WEST SUSSEX COUNTY COUNCIL CONSULTATION

TO:	Arun District Council FAO:Michael Eastham
FROM:	Stephen Gee, WSCC - Highways Authority
DATE:	19 March 2019
LOCATION:	Land east of Tye Lane Walberton Arun.
SUBJECT:	WA/11/19/DOC Approval of details reserved by condition imposed under ref WA/44/17/OUT relating to Condition Nos 15 layout & specification of & construction programme roads, footpath, cycleways and parking areas, 19 fire hydrants and 23 air quality & noise impact assessments.
DATE OF SITE VISIT:	
RECOMMENDATION:	Objection / Modification/Further informatio
S106 CONTRIBUTION TOTAL:	£ See below for breakdown.

The application is for the discharge of conditions relating to the construction of 175 dwellings at Land East of Tye Lane approved under application ref WA/44/17/OUT

SWEPT PATH ANALYSIS, REFUSE
LOCATIONS AND SITE ACCESS DRAWING

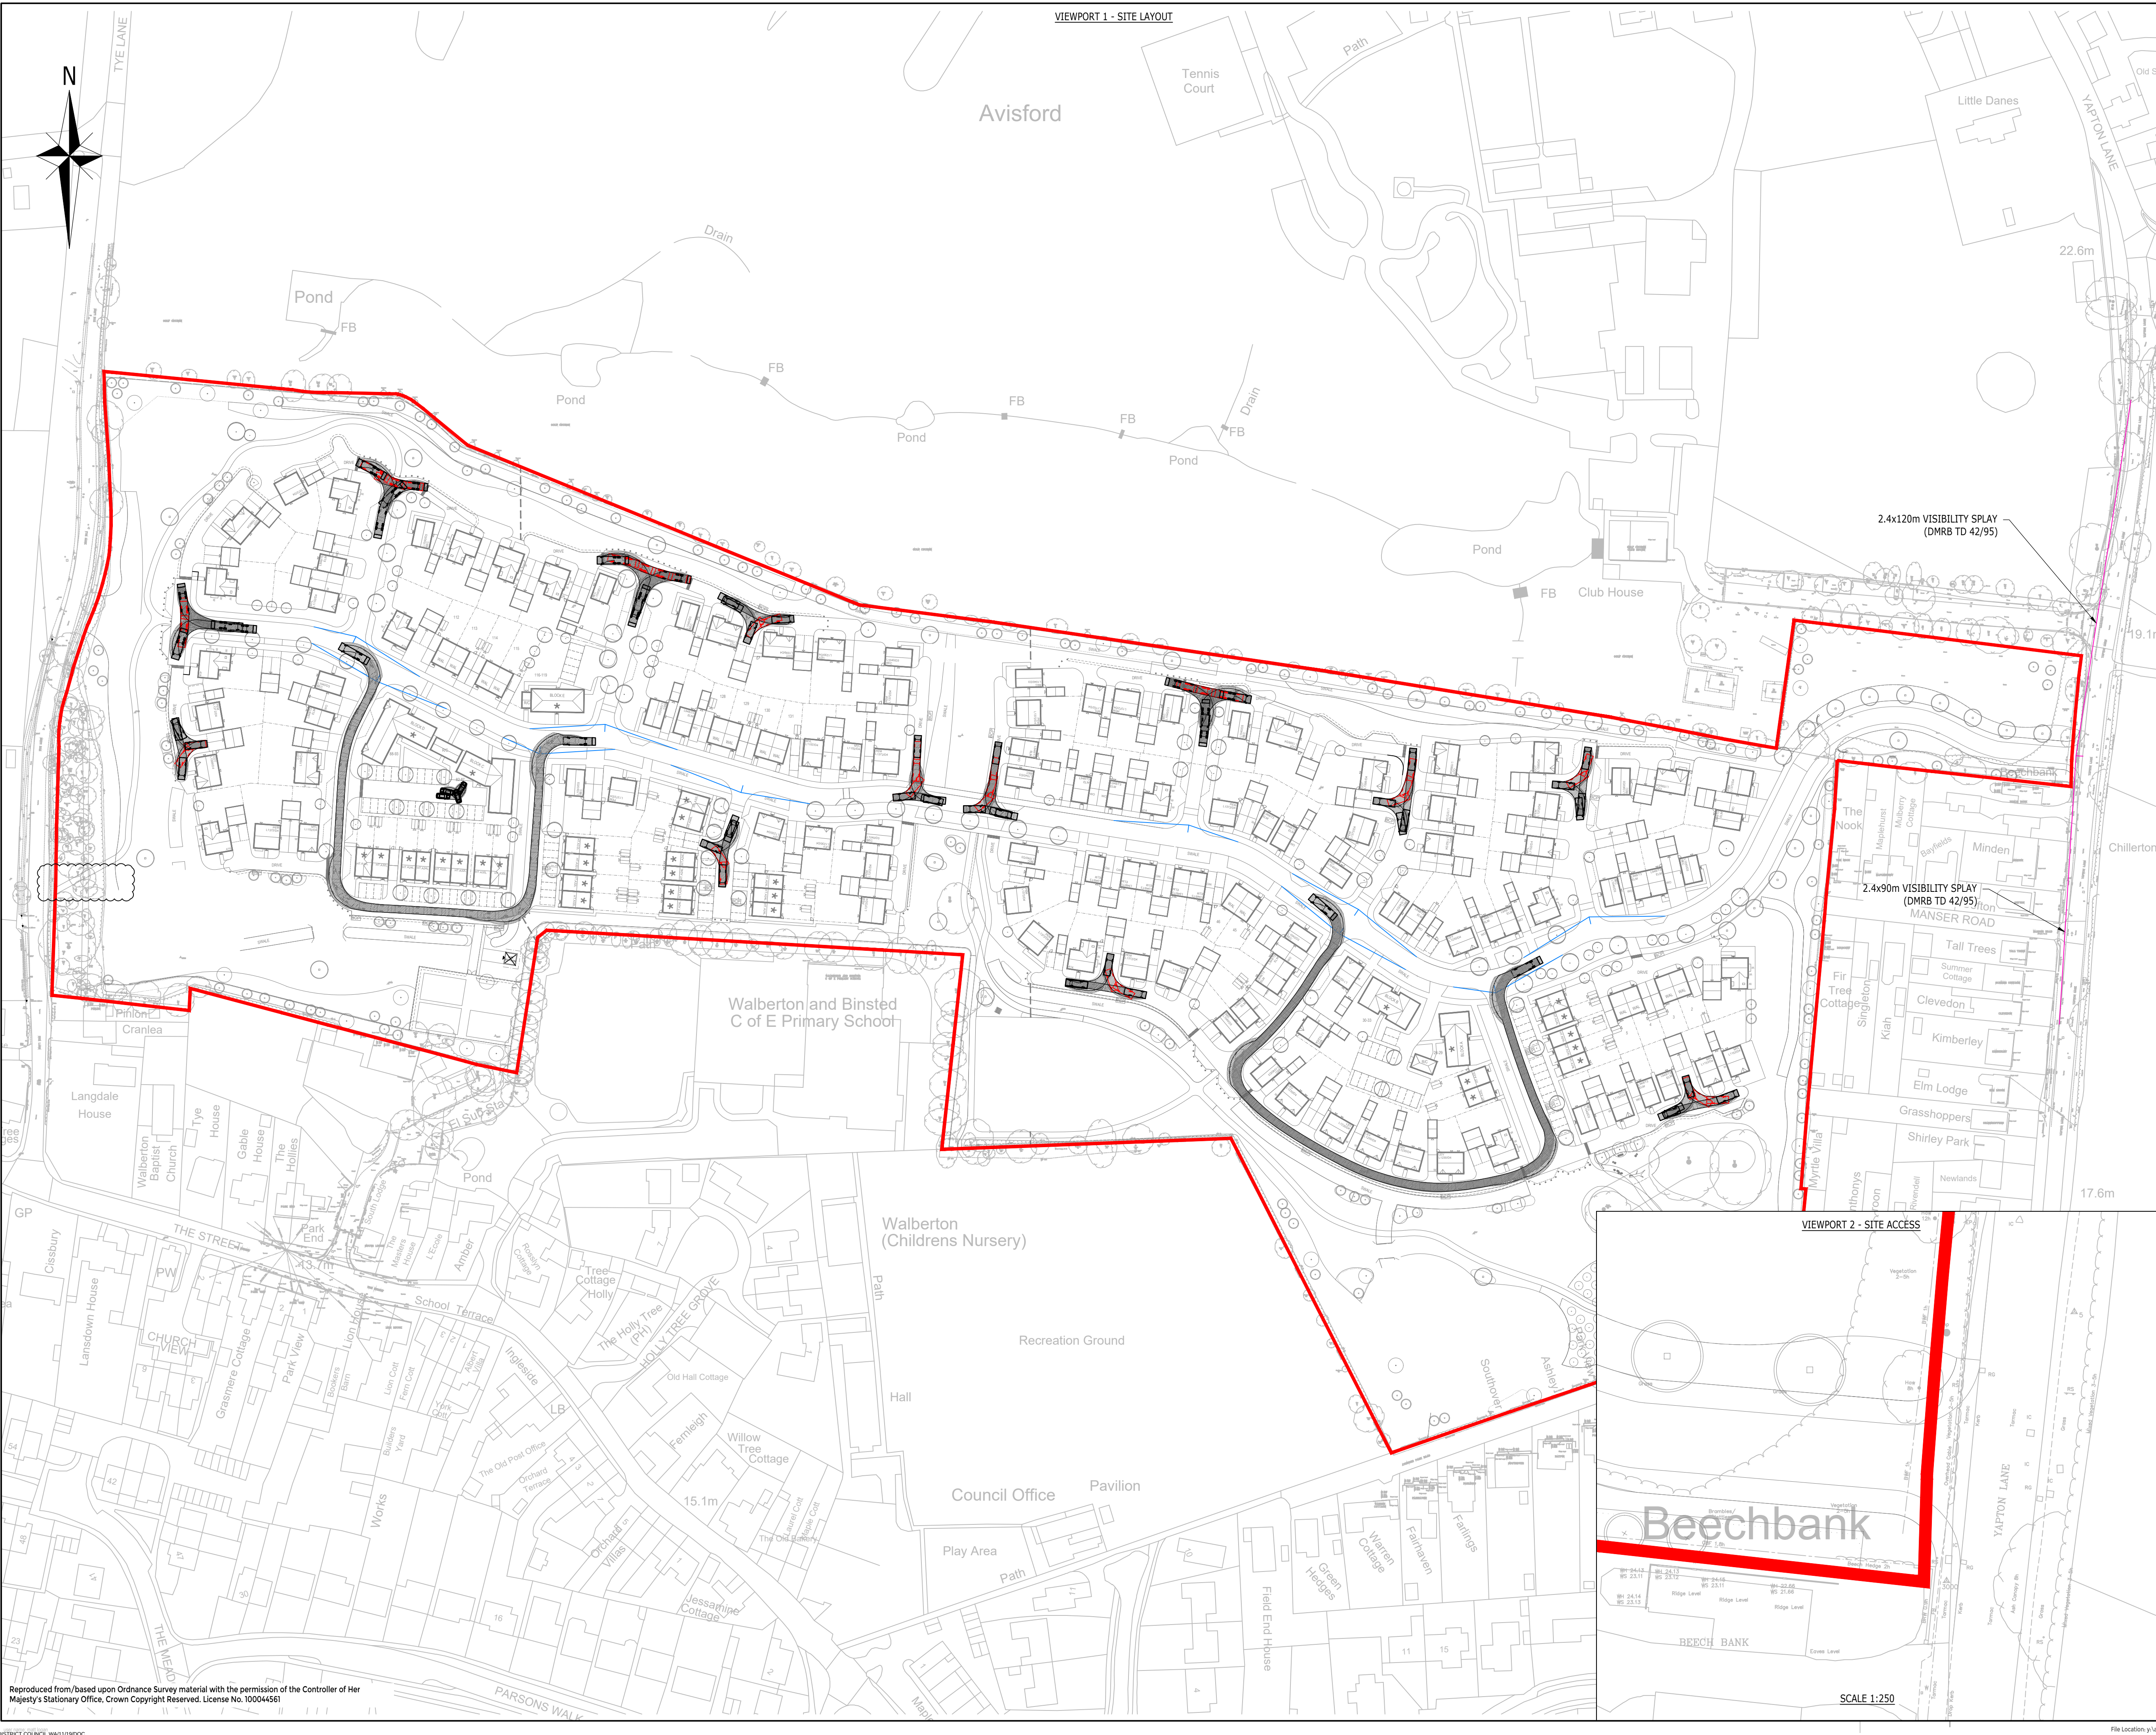
- The plan should include the footpath link shown on drawing ref CSA/3823/109 REV C submitted as part of the reserved matters application at the south eastern extent of the site which would link into Avisford Park Road.

- The plan should include the southern footway cycle way to the south West of the site linking to Tye Lane, details are also required on the width of such provision and any measures to reduce the potential for cyclists overshooting the junction as recommended within the safety audit provided as part of application WA/44/17/OUT

An objection to the discharge of condition is raised. The applicant should provided amended plans/additional details as outlined above.

Drawing Title:
**PROPOSED CONSTRUCTION
PHASING PLAN**

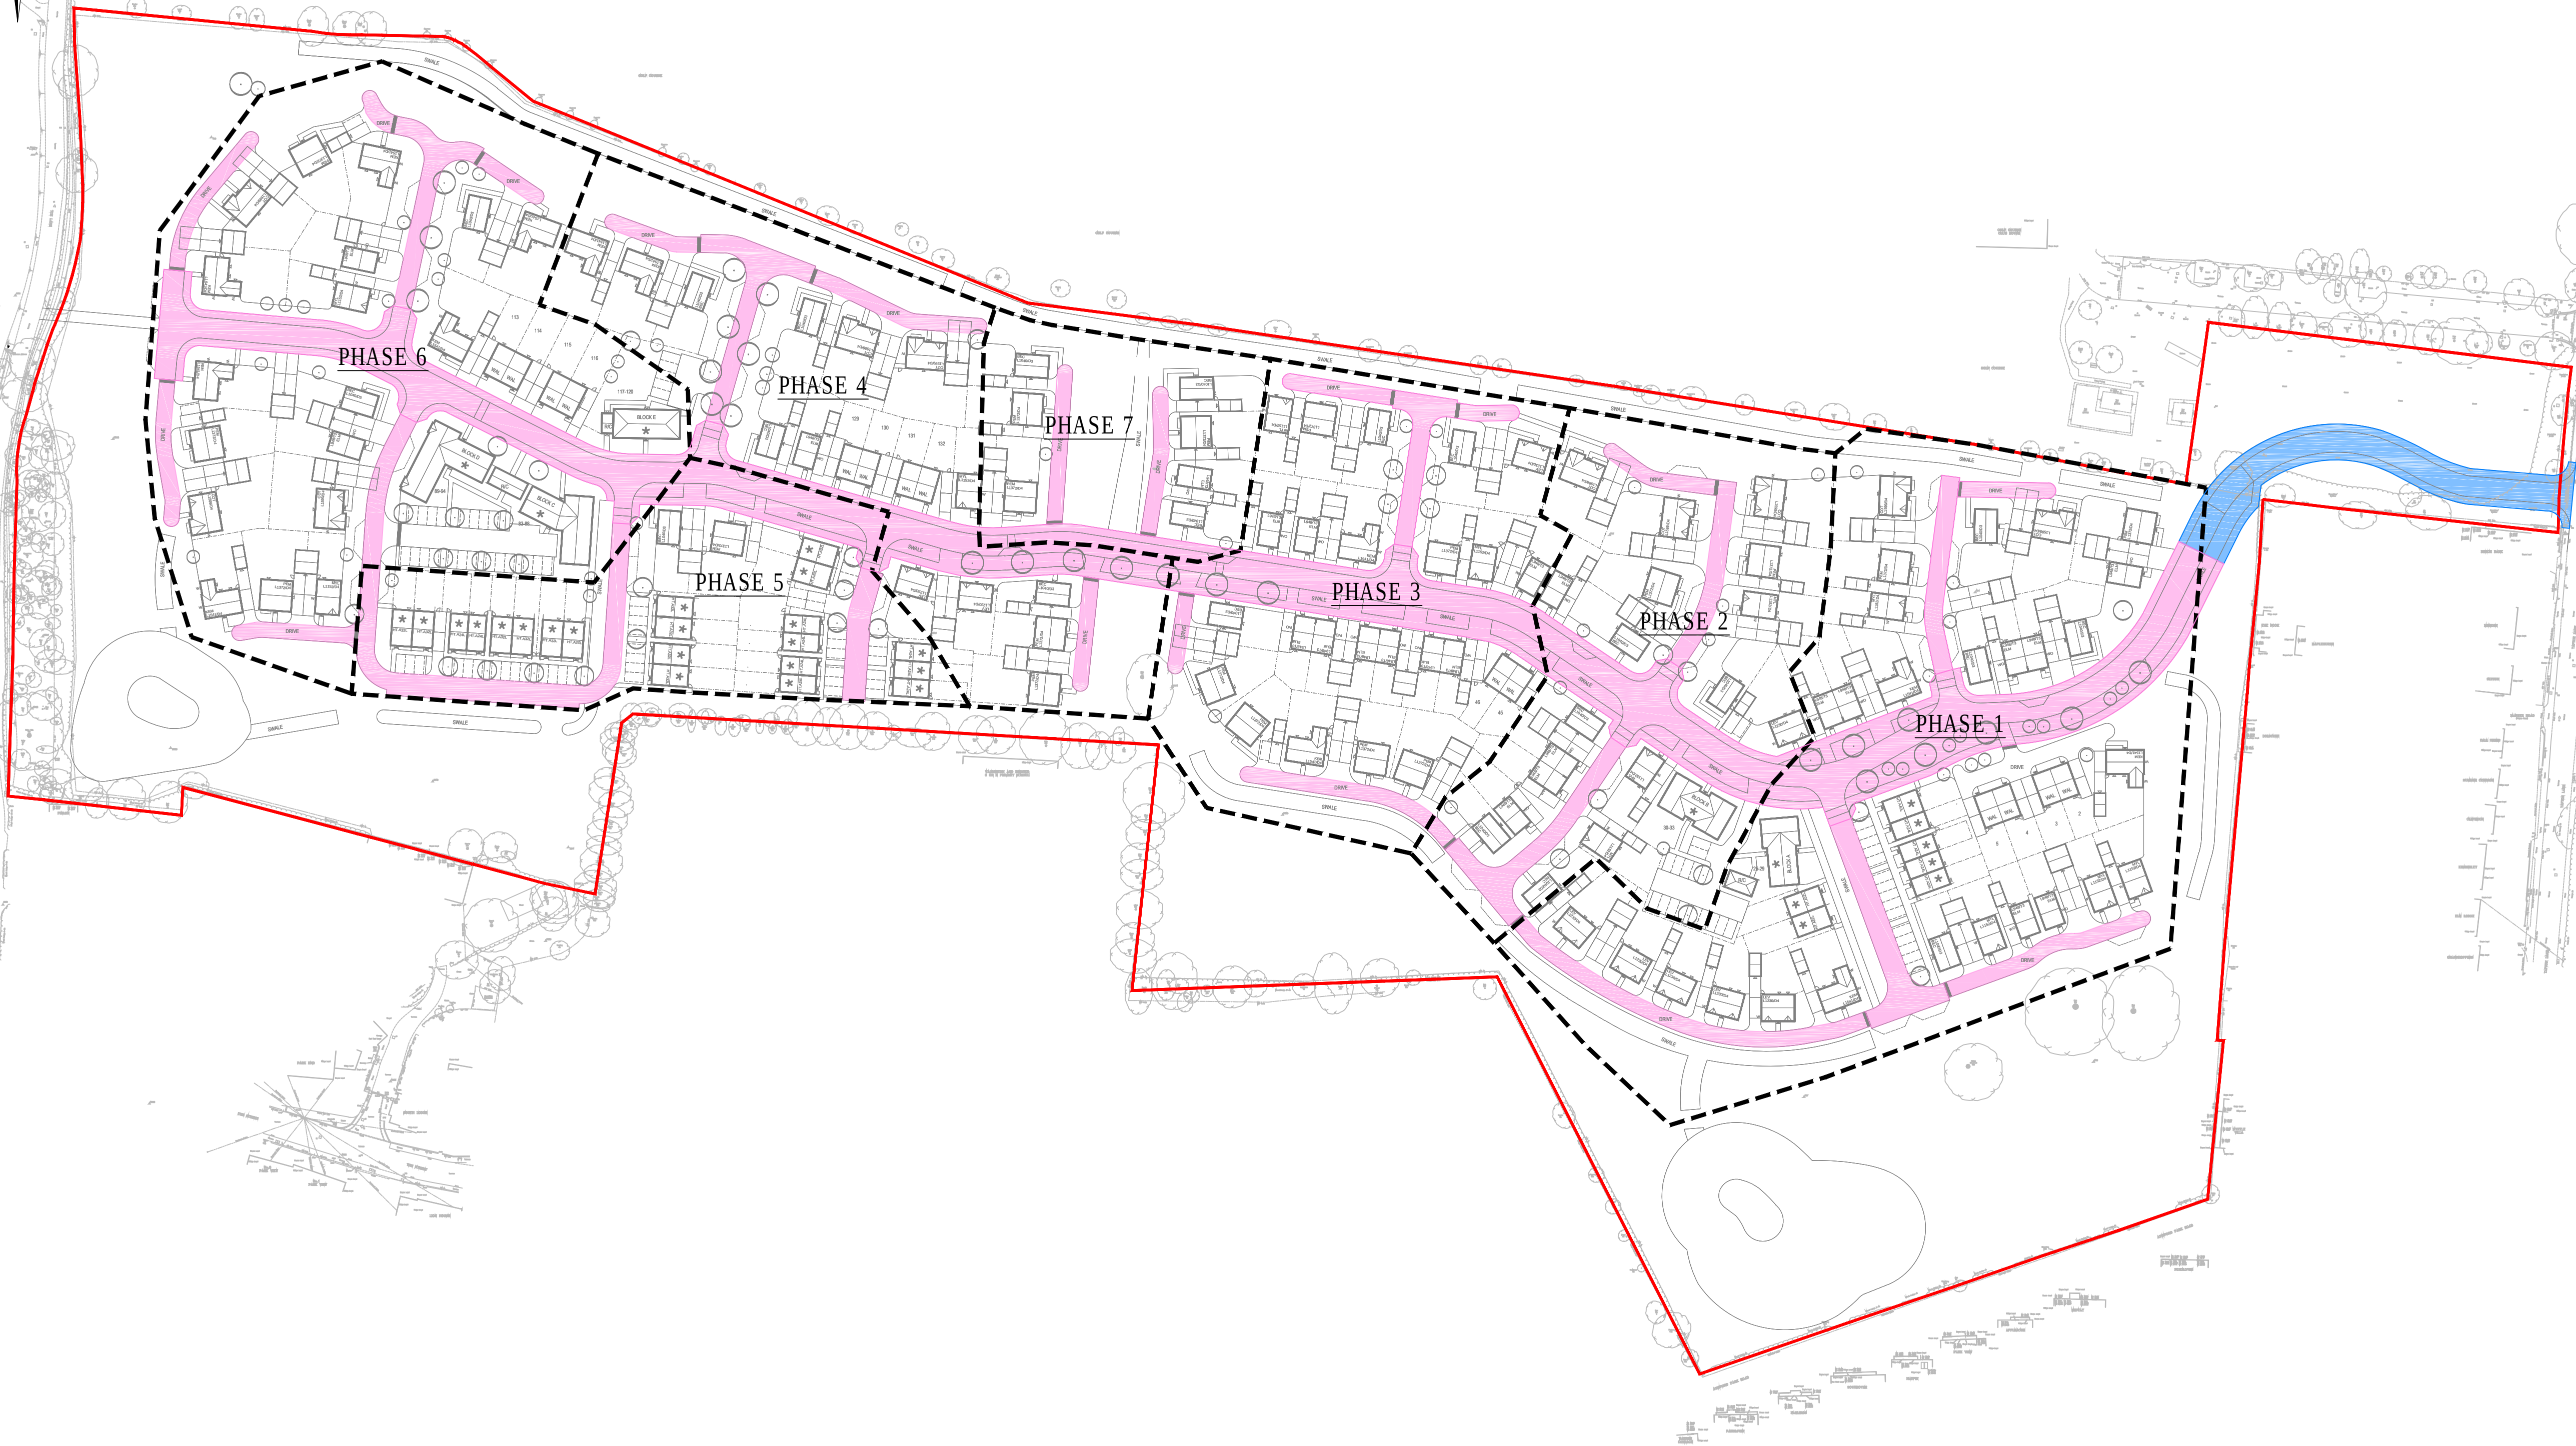
- A revised plan should be provided showing the construction phasing of the footpath and cycle way links to the south east and south west of the site linking to Avisford Park Road and Tye Lane.
